RE: Maine Yacht Center Phase II - 100 Kensington Street
Building Code Design Review

Structural Special Inspections

| FILE NAME: \N\ROGER\2003\030017 Maine Yacht\STR4.dwg | | <p>Engineering Designs For</p> <p>MAINE YACHT PORTLAND, MAINE</p> <p>UNIT 3 STAIR DETAILS</p> <p>DESIGN BUILDER</p> | |

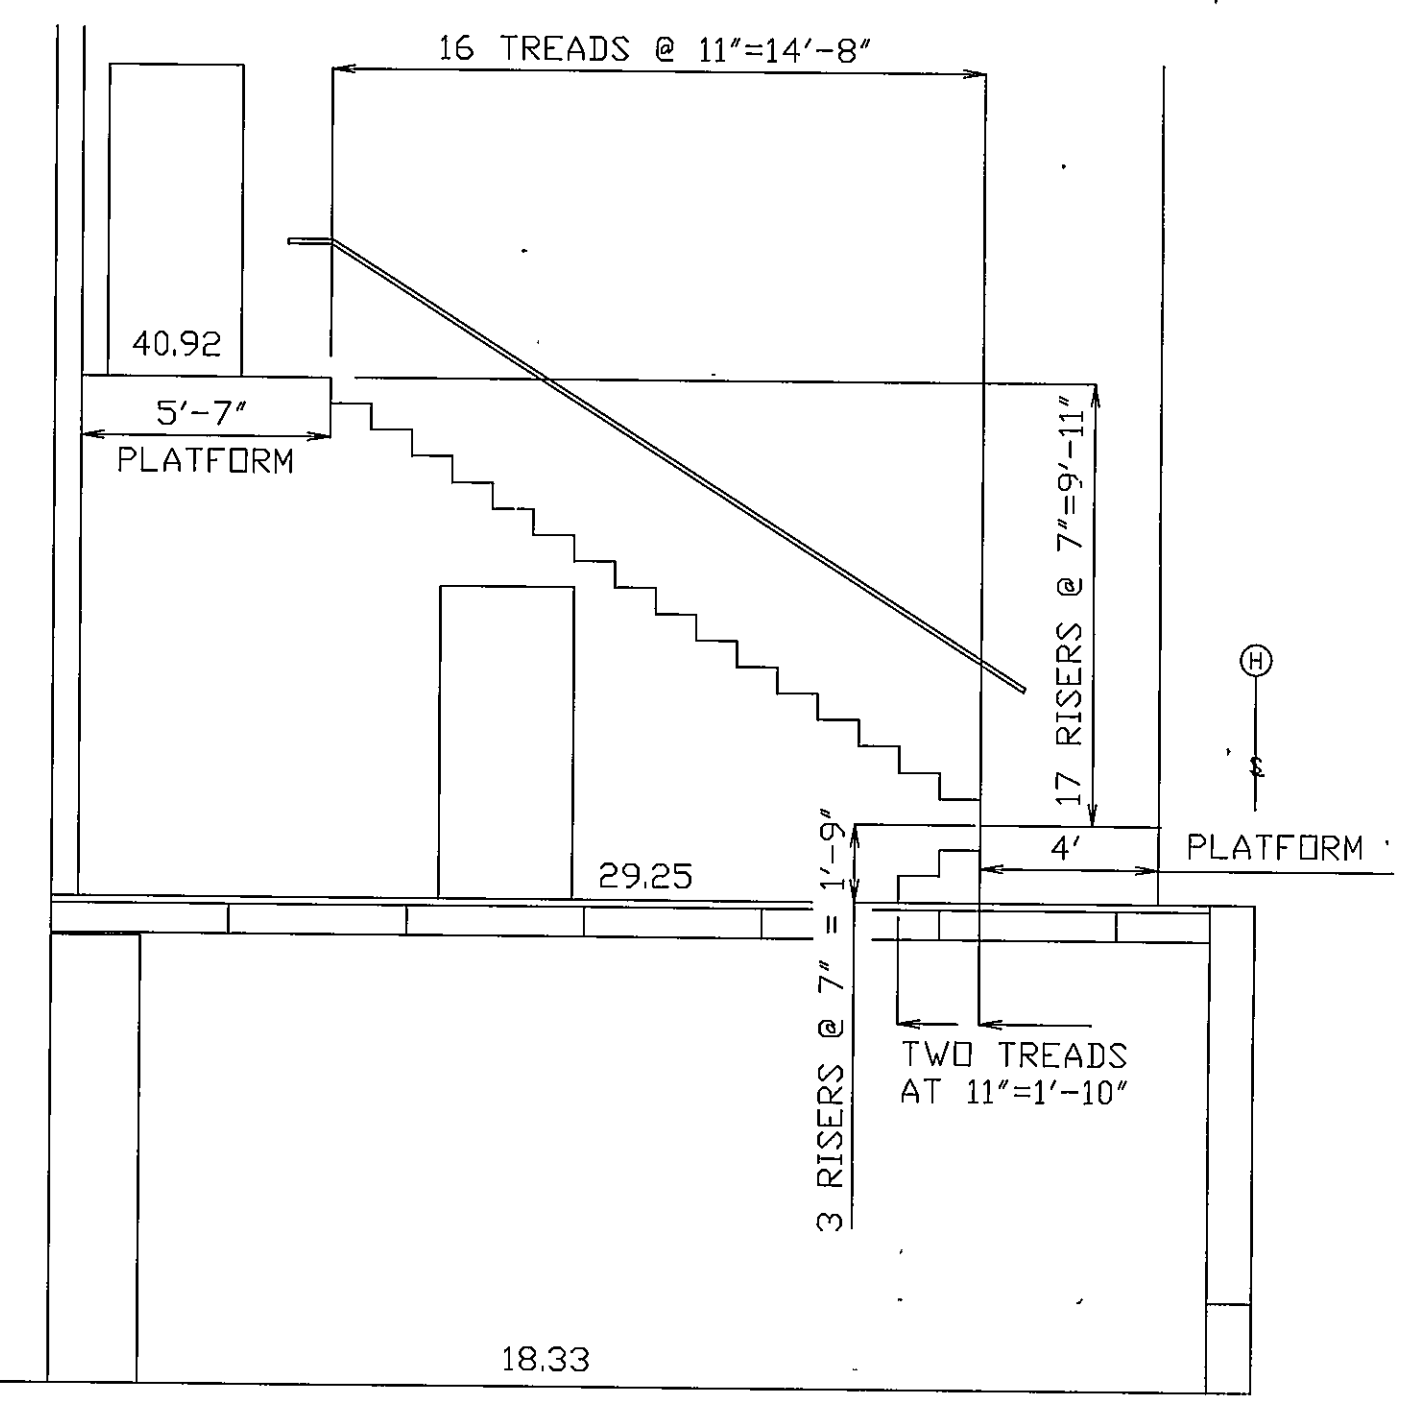
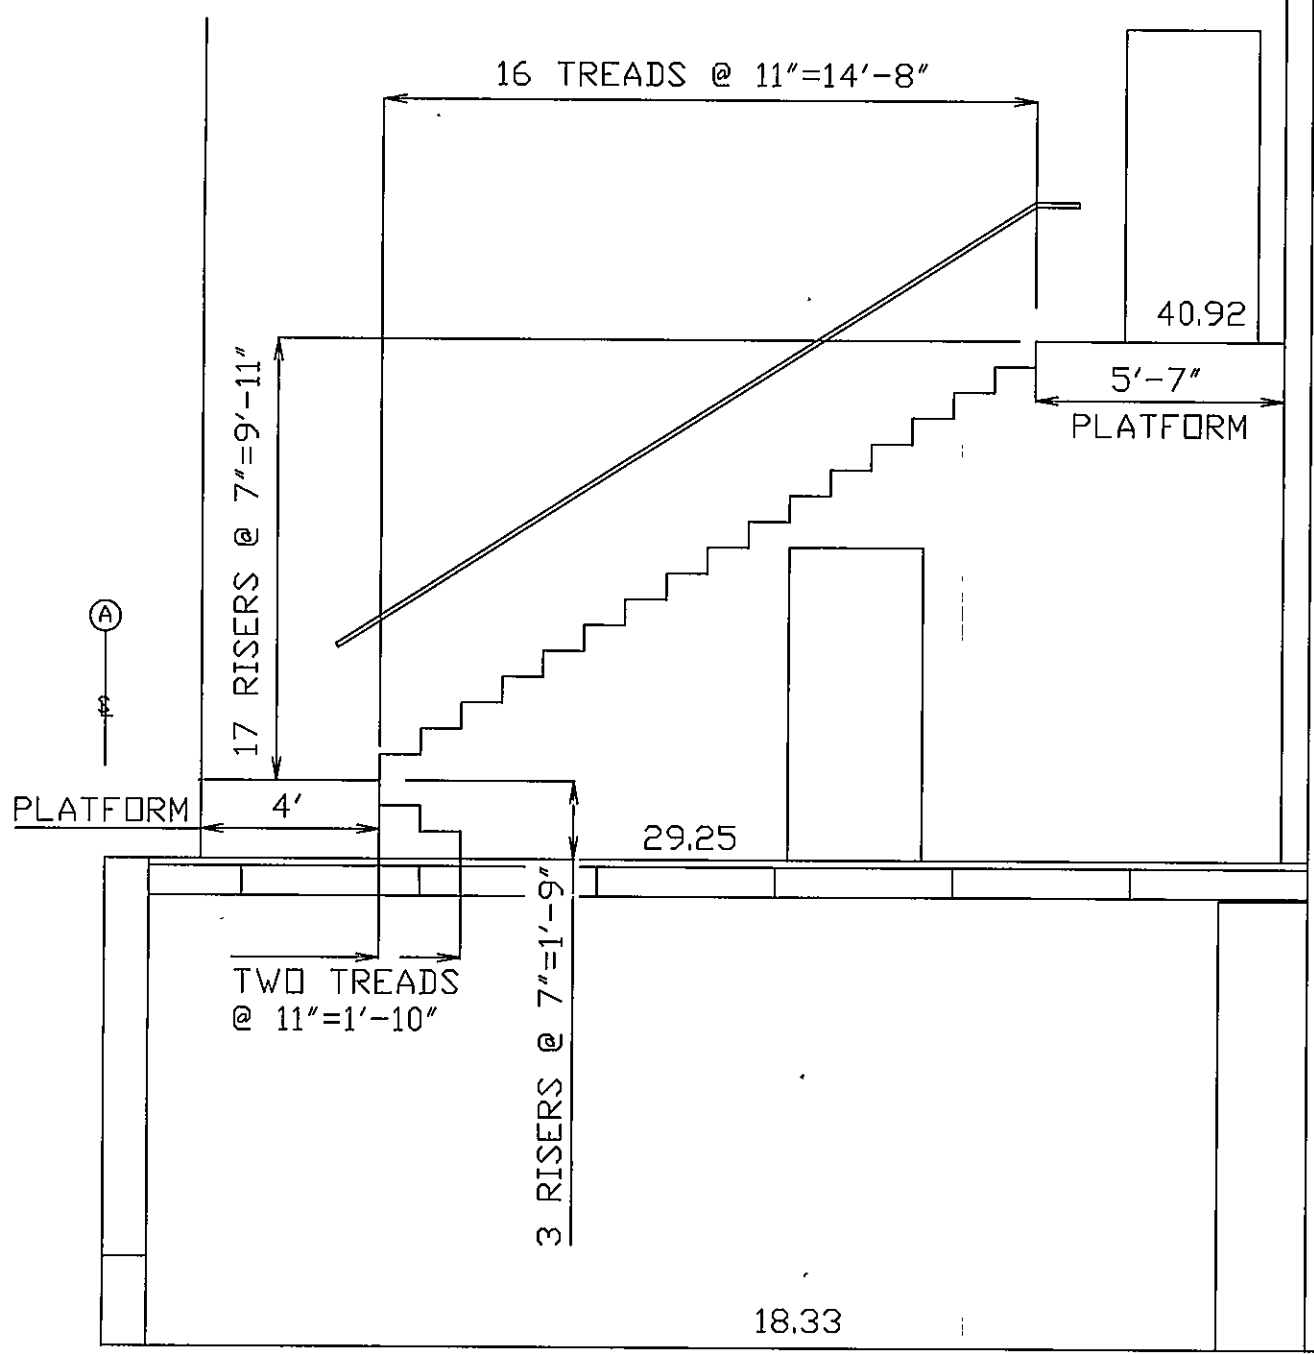
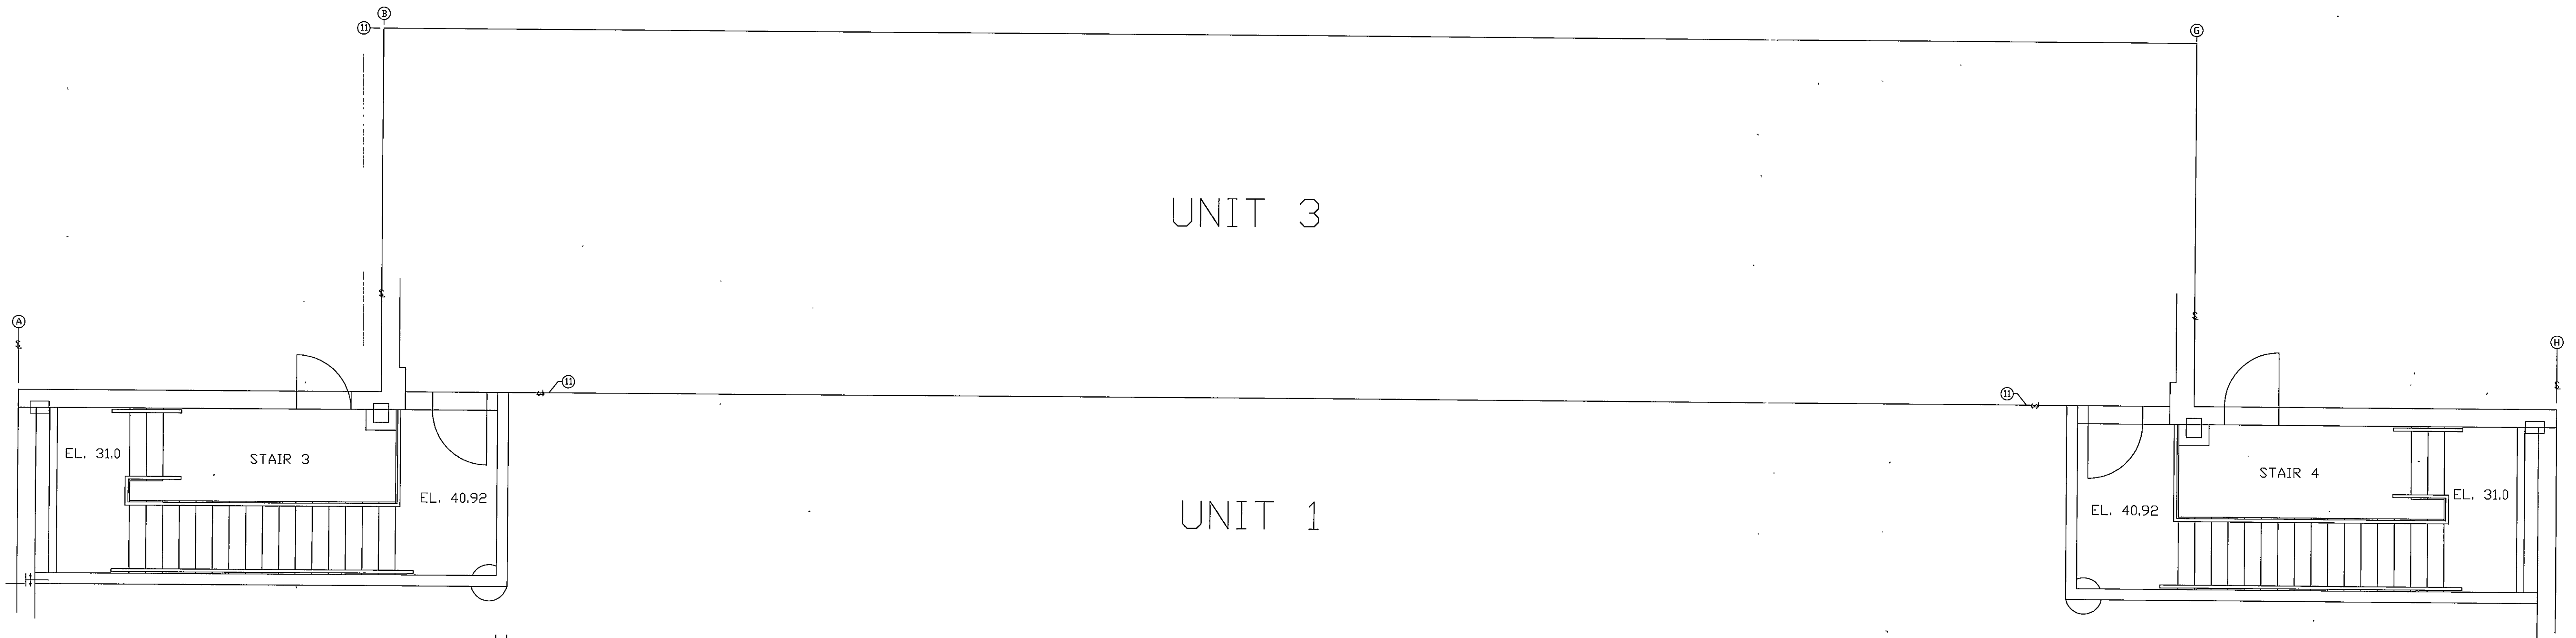
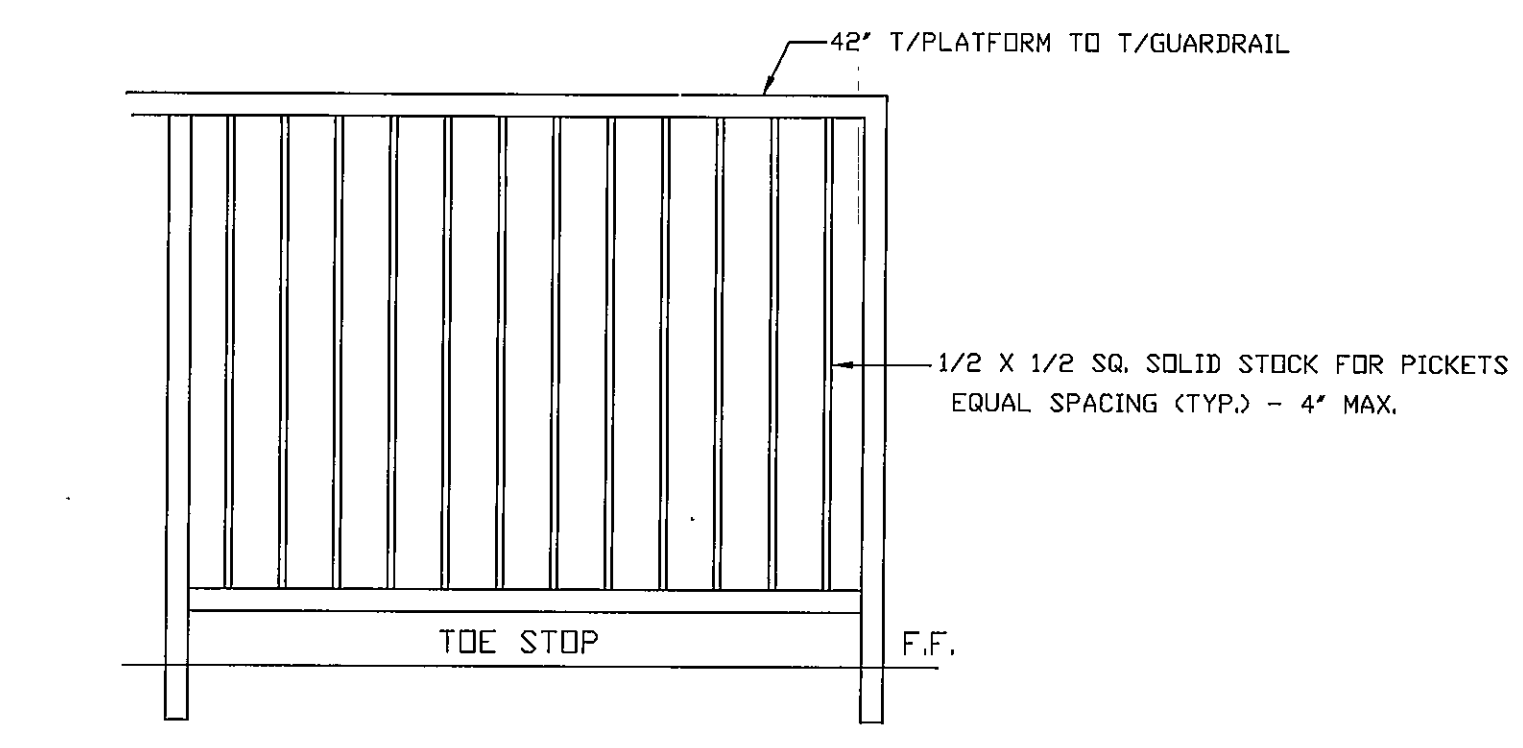
43. Stair tread and rise are not identified.

A3. Granted this could have been more specific although it is identified on Plan Sheet STR-4. All other stairs are to have the same 7" rise and 11" tread. We include our latest plan identifying these elements.

| | | First Floor Plan | |

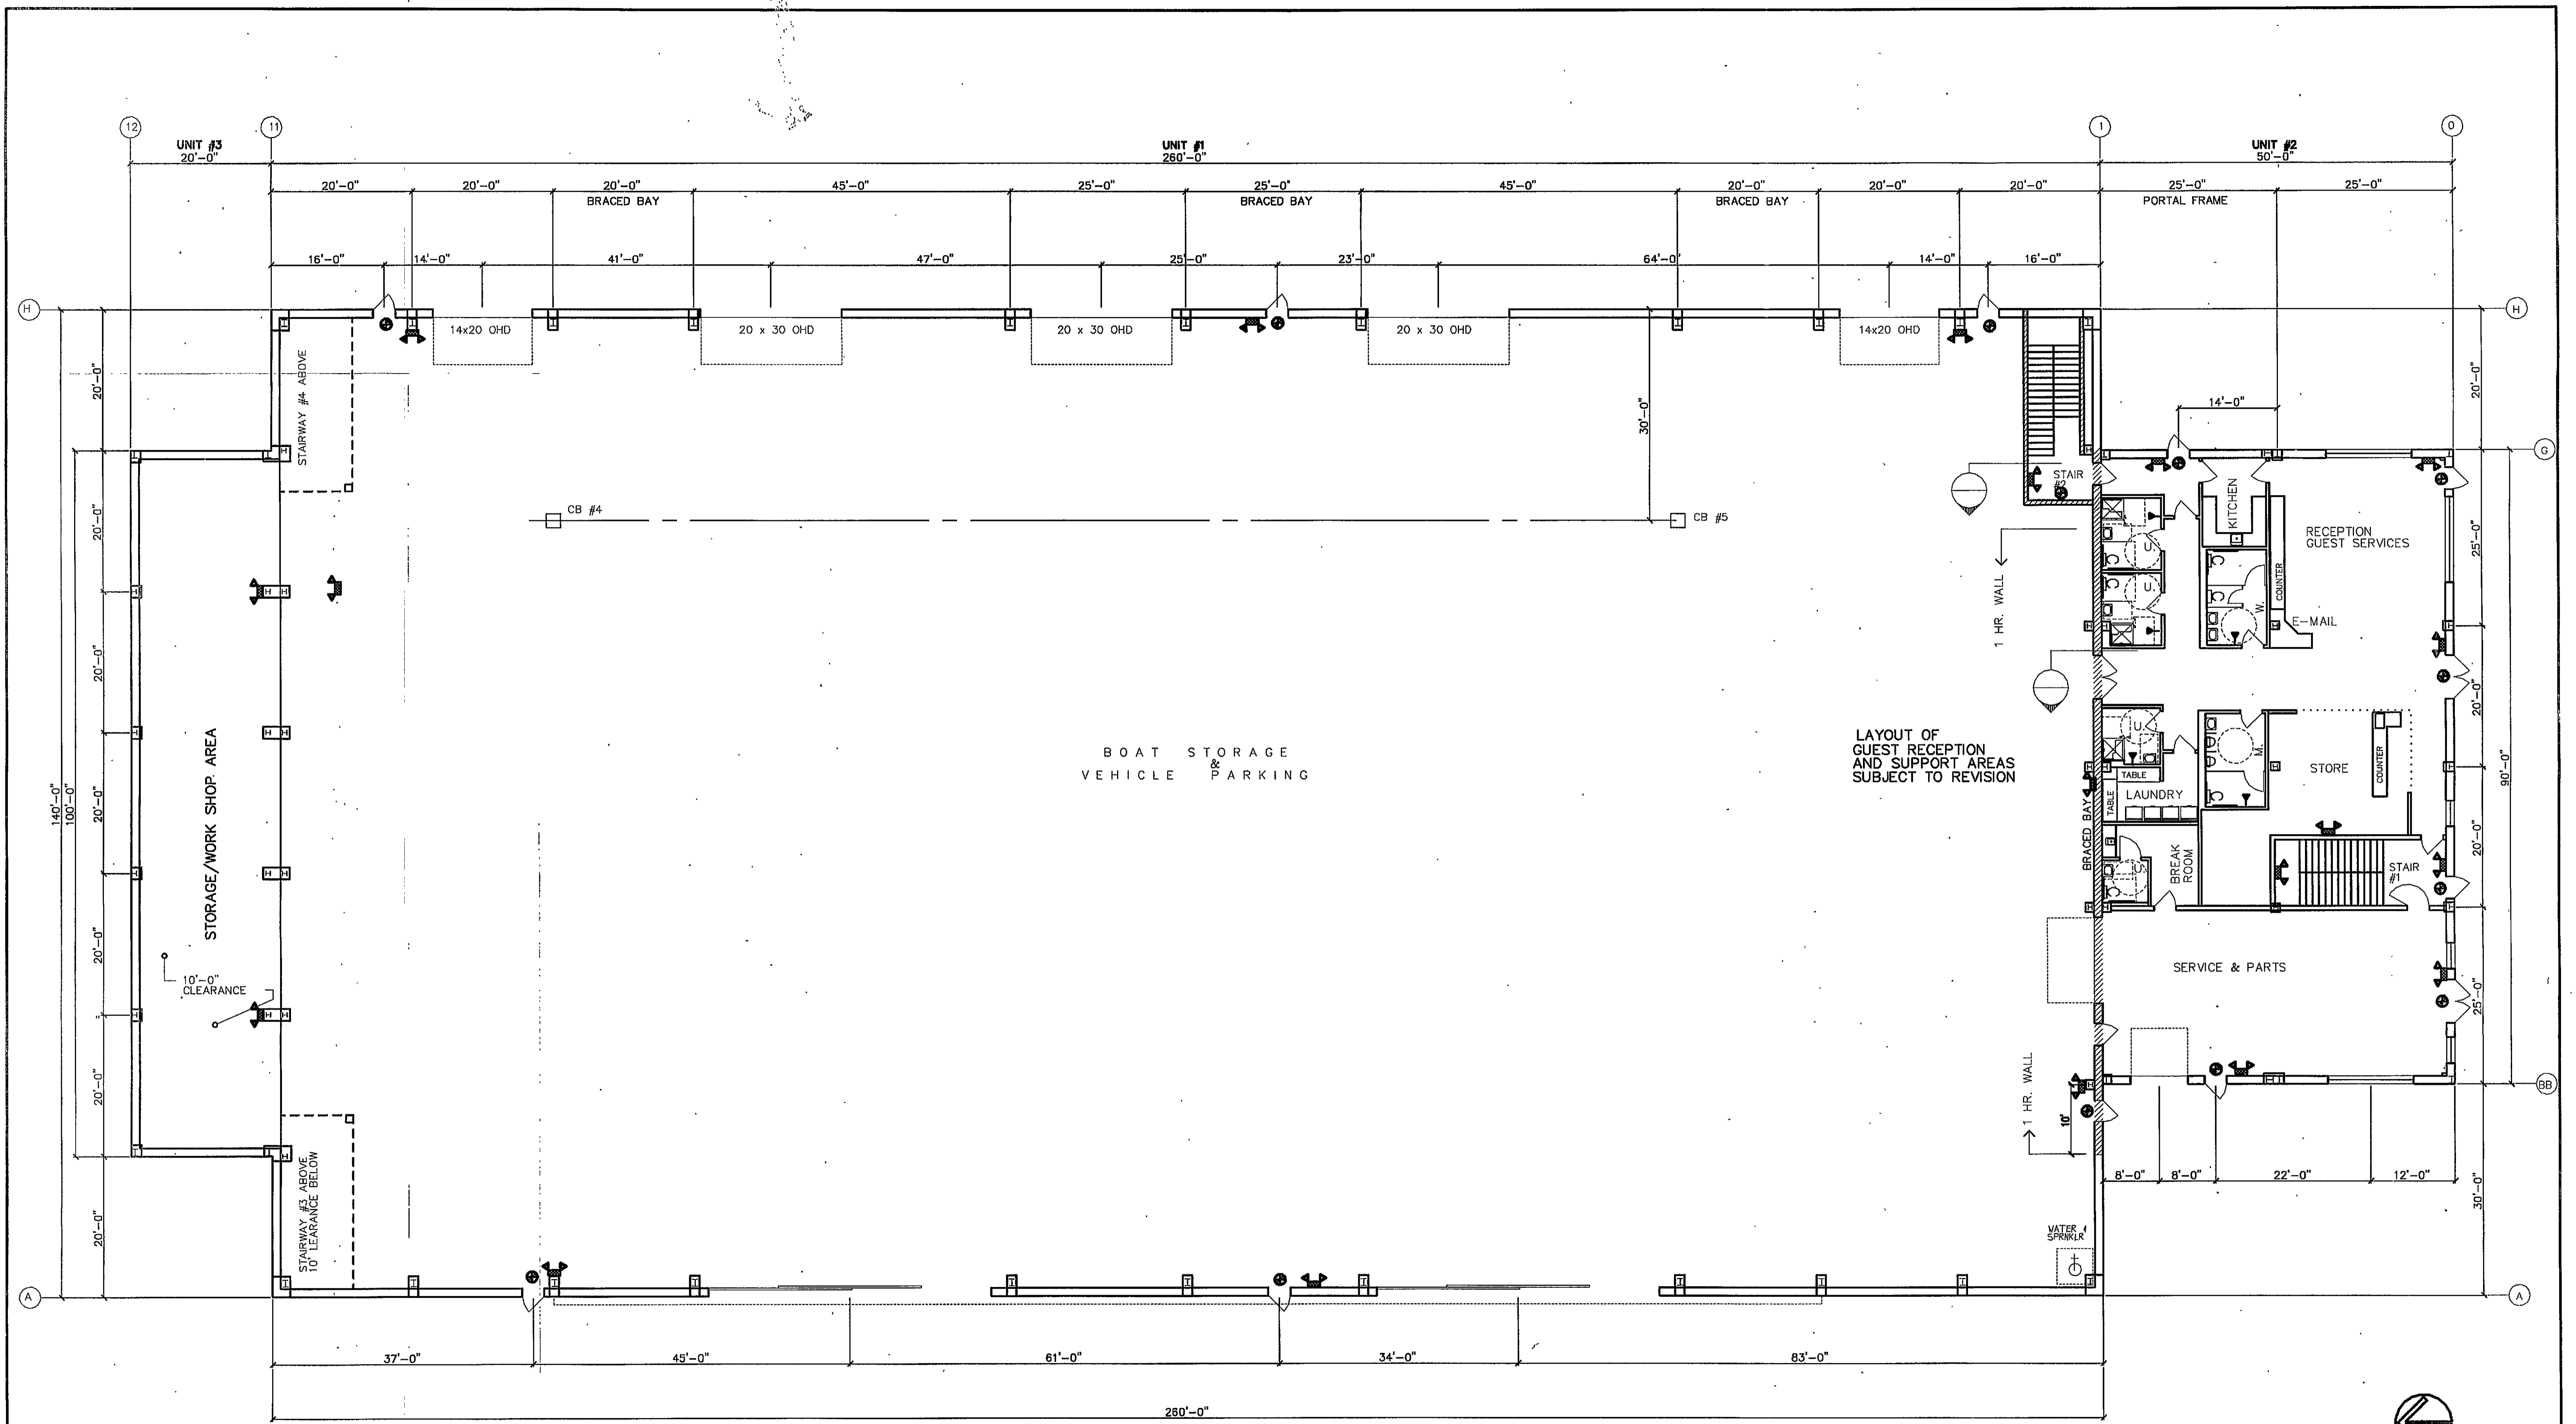
48. Provide information via Section 805 regarding floor and wall finishes and 803.3.2 for wall and ceiling smoke development.

A8. We have shown these finishes on our room and door schedules, Plan Sheet D8. Our client, Maine Yacht Center has not given us a contract for providing flooring or special wall finishes in any of the building units. We will provide 5/8" Type X gypsum for the fire separation walls and the exterior walls on the first floor of Unit #2. All other spaces in Unit #1, Unit #2 or and Unit #3 have no other interior wall or floor finishes. Floors will be unfinished concrete at this juncture. We will be providing a suspended ceiling in the Unit #2 first floor. Our supplier has not yet been determined so any further information is unavailable at this time; however we certify that the ceiling material smoke development index will be less than 450 as per BOCA 803.3.2.
